Ref: Planning ApplicationBR/27/11

Ref: Planning Applications BR/25/11 & BR/27/11

Revisions to Approval BR/254/10/ comprising 1 no. additional dwelling (Plot 3)
14 Ivydale Road Bognor Regis

Site Layout Plan at 1 : 200 scale

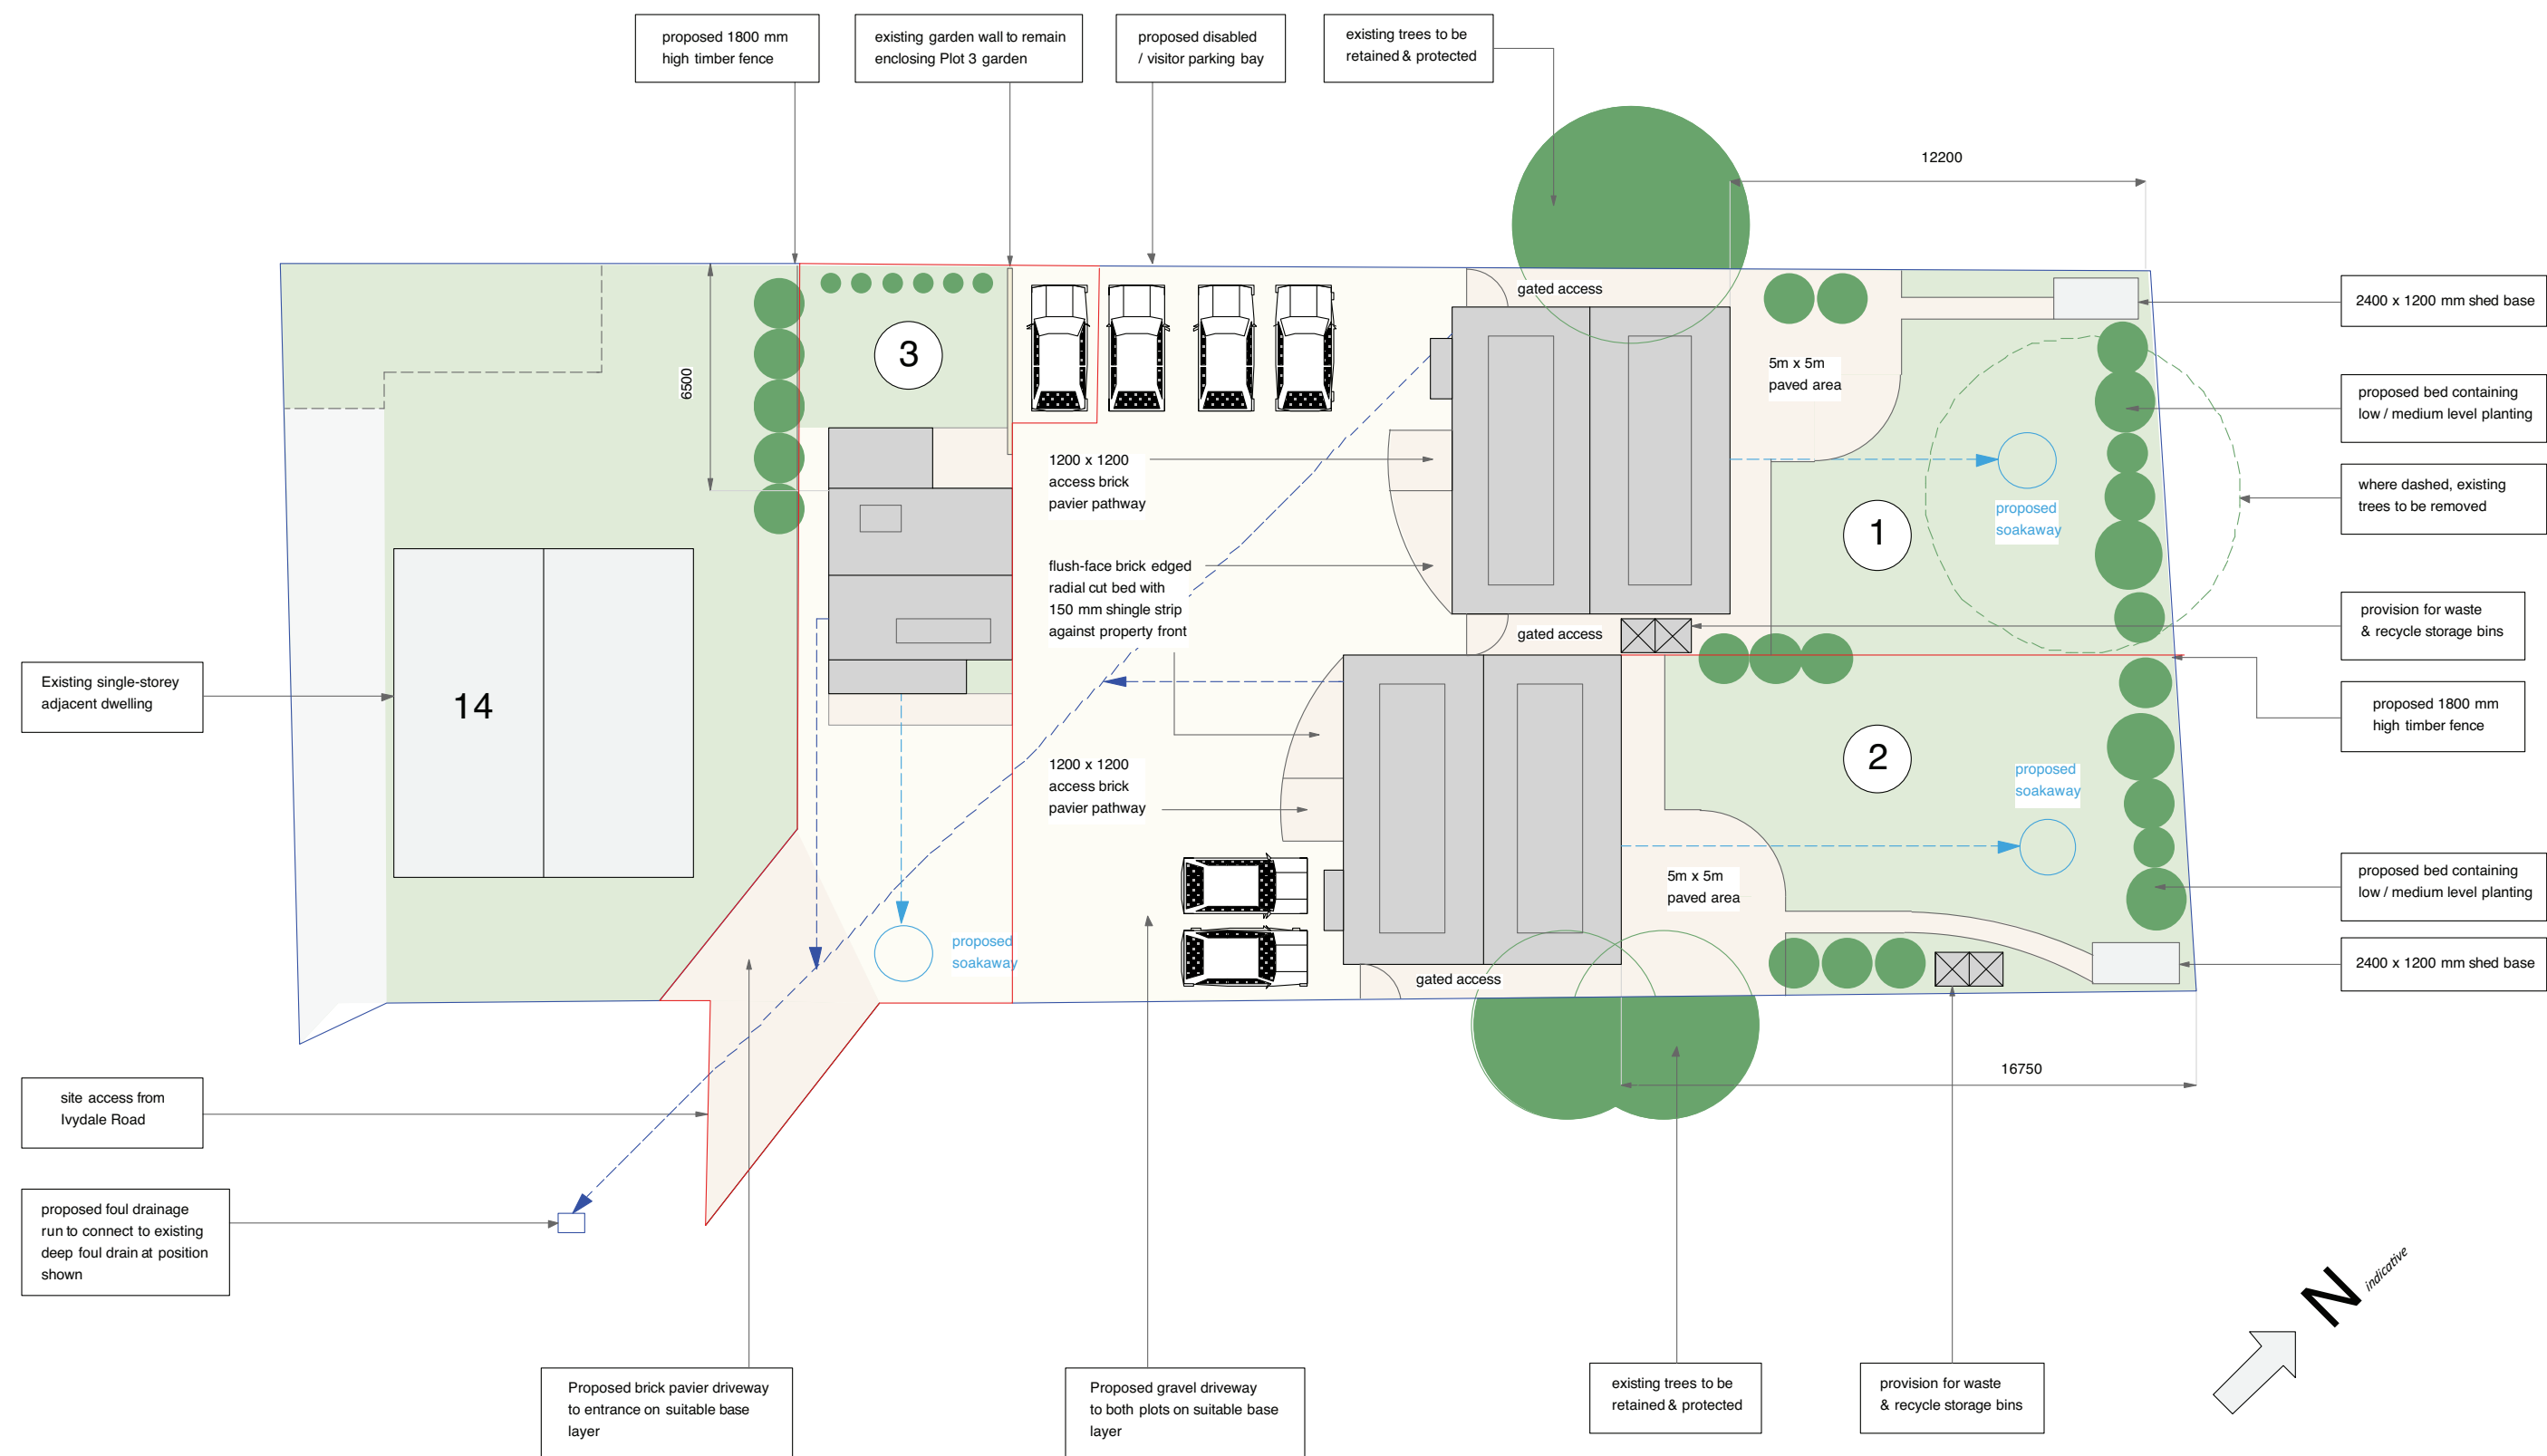
I understand that in addition to the extra property the amended application moves the two houses already approved closer to the back of my property and off all build lines. I therefore object to the amendments. Moving the houses towards gravits lane will reduce the privacy and make what are already large properties on the back of the house completely overbearing.

I would like to object to the proposed plans because the density of housing is inappropriate and out of keeping with the area. Likewise the new dwelling proposed is completely out of character with existing properties in the area. In addition the two dwellings for which planning permission already exists are moved completely off all existing build lines and alignments. If this application should go to review I would strongly suggest that a site visit is made.

The houses have been moved into a position off the build line of existing properties. The proposed small house will make the development too dense for the area and is out of character.
